Application: SSI 7485

I write regarding the proposed modification to M4-M5 Link, Mod 2 The Crescent overpass and changes to pedestrian infrastructure in North Annandale, Rozelle and Rozelle Bay Foreshore area.

Figure 4-4 Elevation: Indicative view of The Crescent overpass

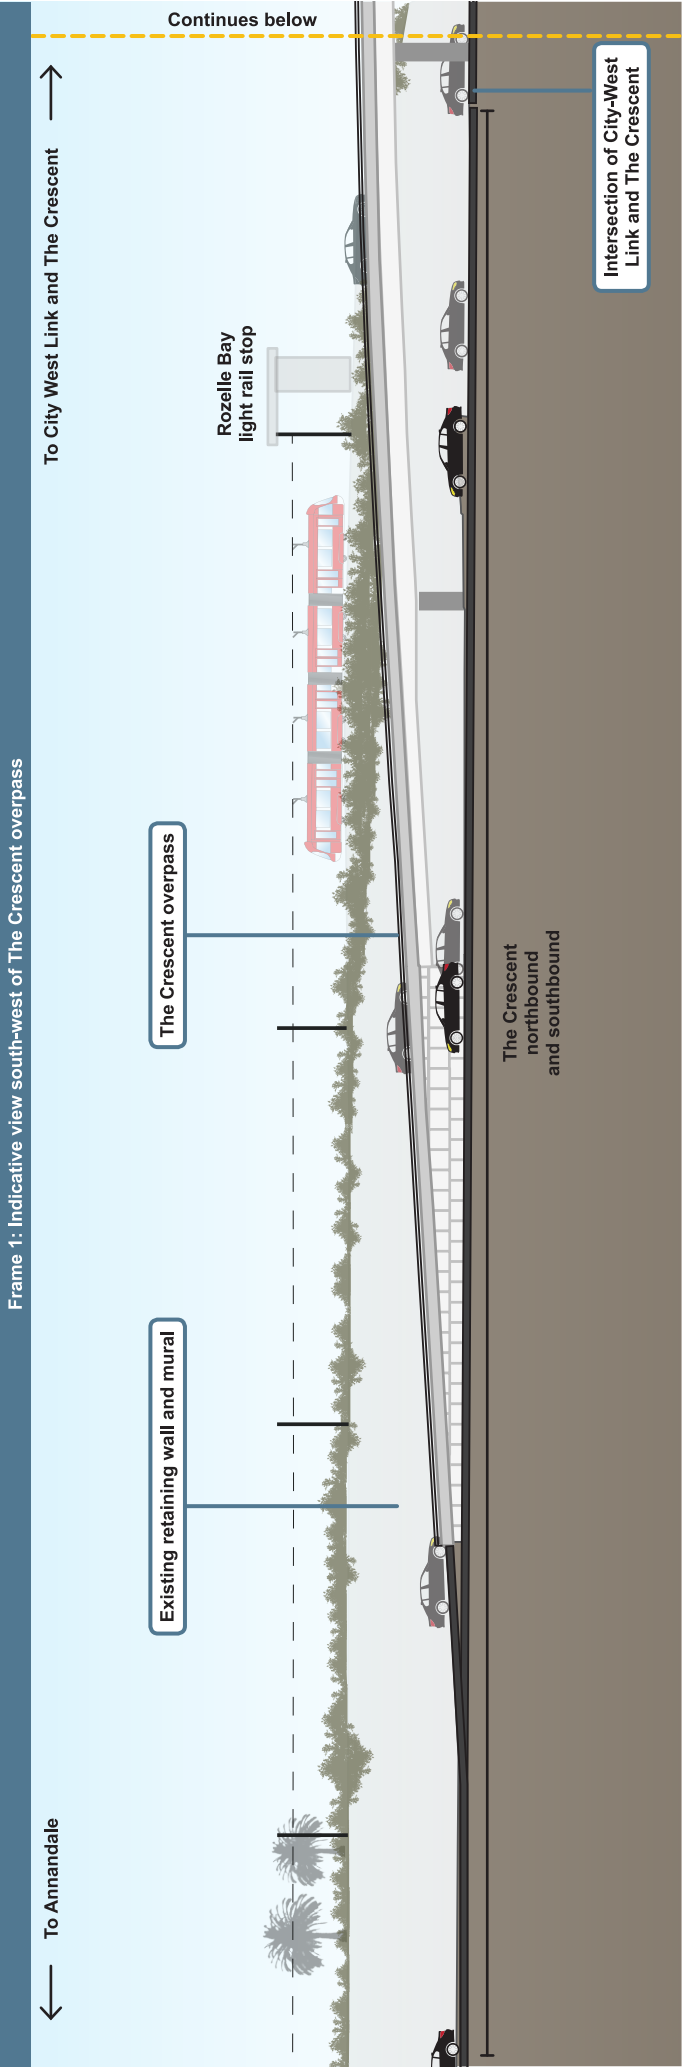
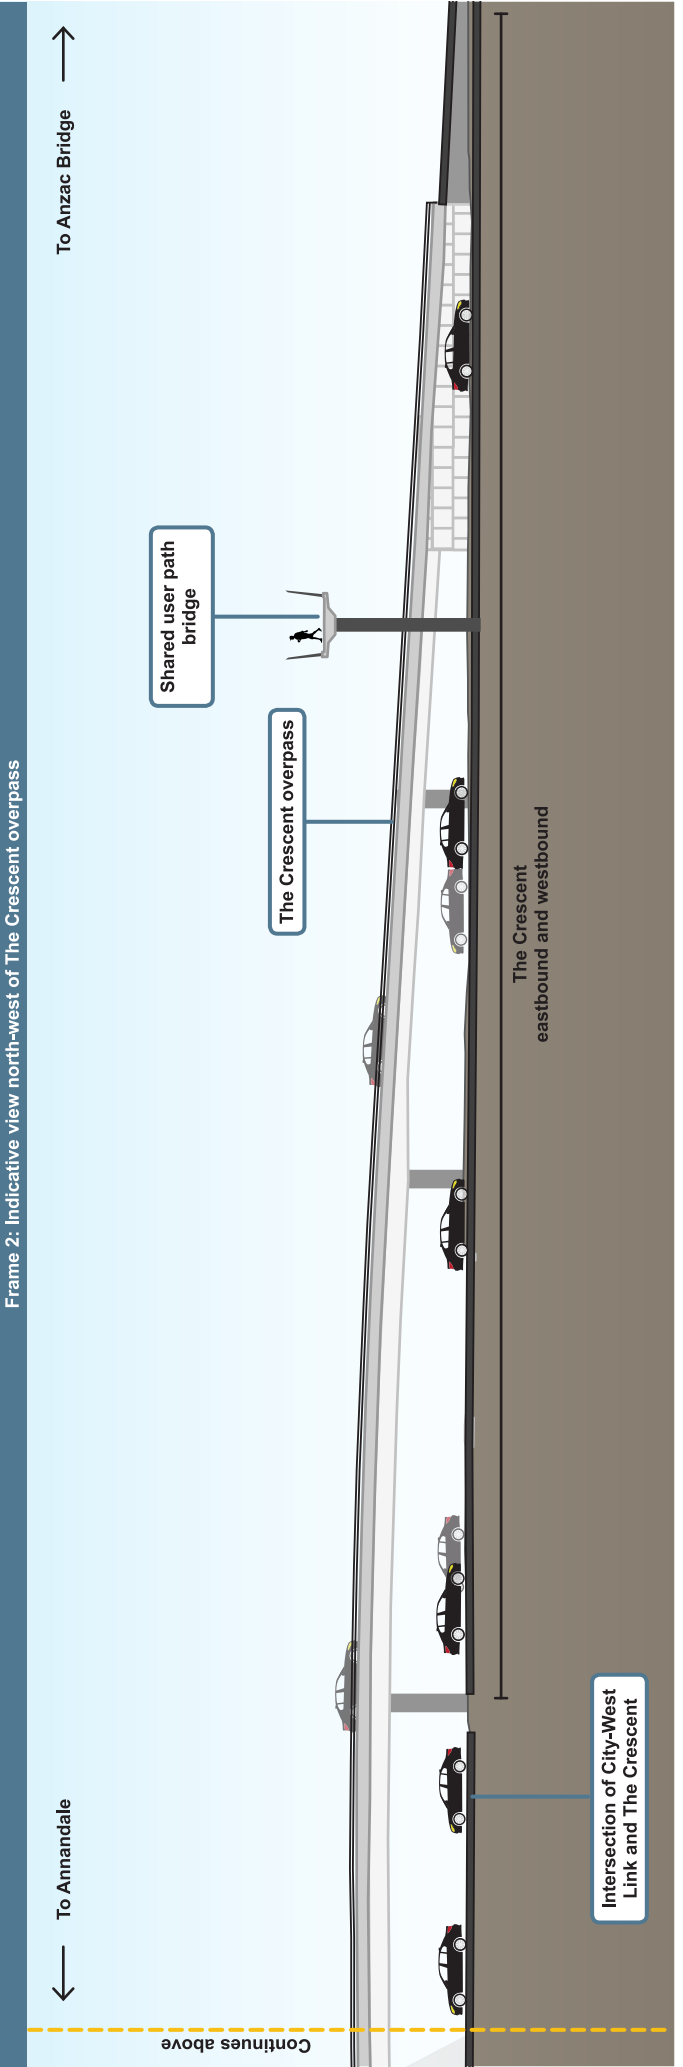
I request RMS work with the community to explore alternate design options to the proposed new car overpass design and the changed pedestrian and cyclist links. I am seeking the reinstatement of the safe, direct access from the approved EIS GreenLink to create a continuous green open space connection from the Rozelle Rail yards and Annandale to the foreshore. The GreenLink was more than just a walk way - it put people central to the design, maximising safety, and providing much needed accessible open space for the community now and into the future Bays Precinct design.

Figure 4-5 The Crescent/Johnston Street/Chapman Road intersection

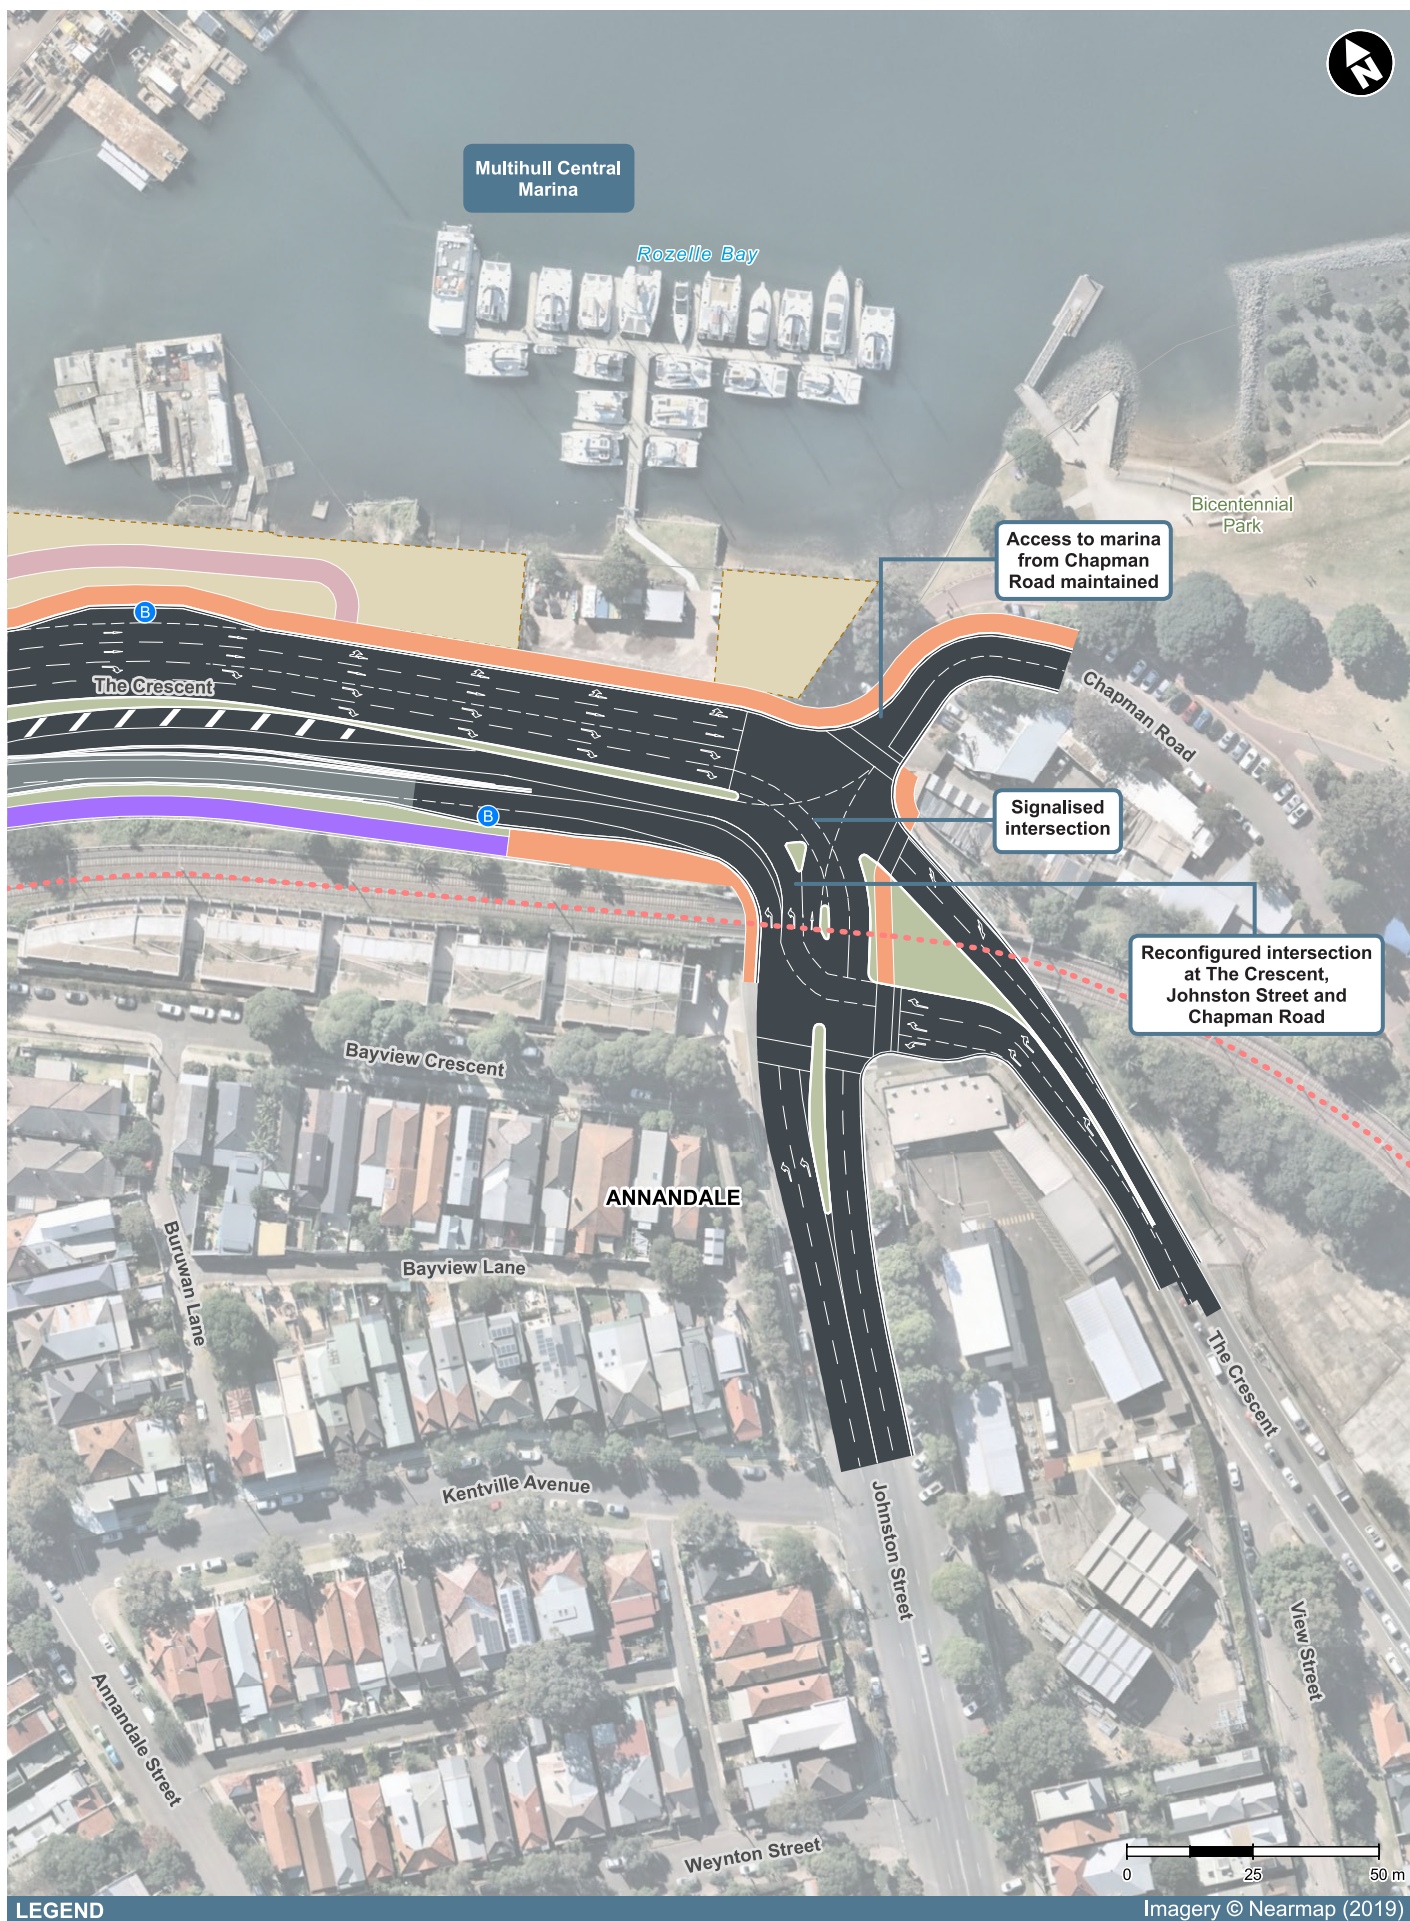
- The significantly reduced safety and increased risk for pedestrians and cyclists with removed access over The Crescent to Bicentennial Park and the increased traffic along Johnson Street.
- Being required to cross five sets of pedestrian lights at The Crescent as my option to reach the foreshore from Annandale or from Rozelle Bay light rail stop.
- Removal of direct active links to the foreshore, cutting the community off from the area and the proposed revitalisation of the entire Bays Precinct, including linking the Light Rail and Bus stops to a Ferry wharf and Metro station.
- Urban and landscape design that is being built before a finalised Masterplan for the area.
- Traffic changes that limit movements around the suburb and create further congestion in the local streets of Annandale, Forest Lodge, Glebe, Lilyfield and Rozelle with no planning to deal with these.

Figure 4-6 Elevation: Indicative view of Rozelle Rail Yards Pedestrian and Cycling Green Link

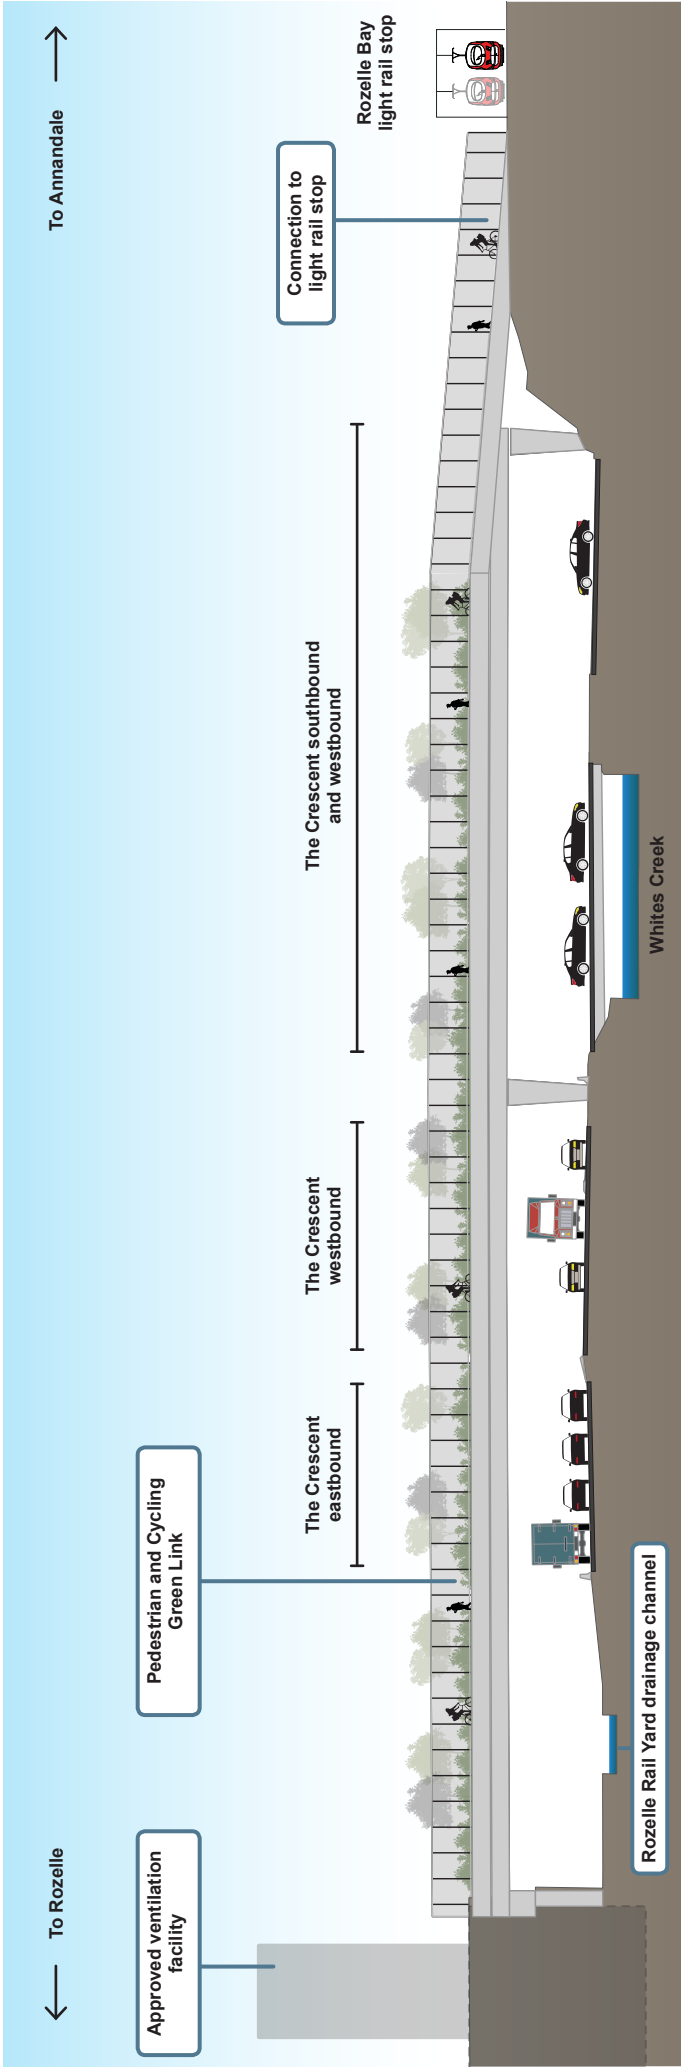
- Reinststate the GreenLink connecting communities and green open space from Rozelle to Bicentennial Park
- Relocate and design pedestrian and cyclist connections that are continuous, safe and direct.
- Design the modification infrastructure and active links in response to the character of the suburbs, the location of the foreshore and it's potential future development.
- Provide pedestrian and cyclist paths that maximise people safety and do not force them onto busier streets, unsafe concrete plazas and caged walkways.
- Integrate active and direct connections to all active transport – including the future Metro West and Foreshore Ferry Wharf
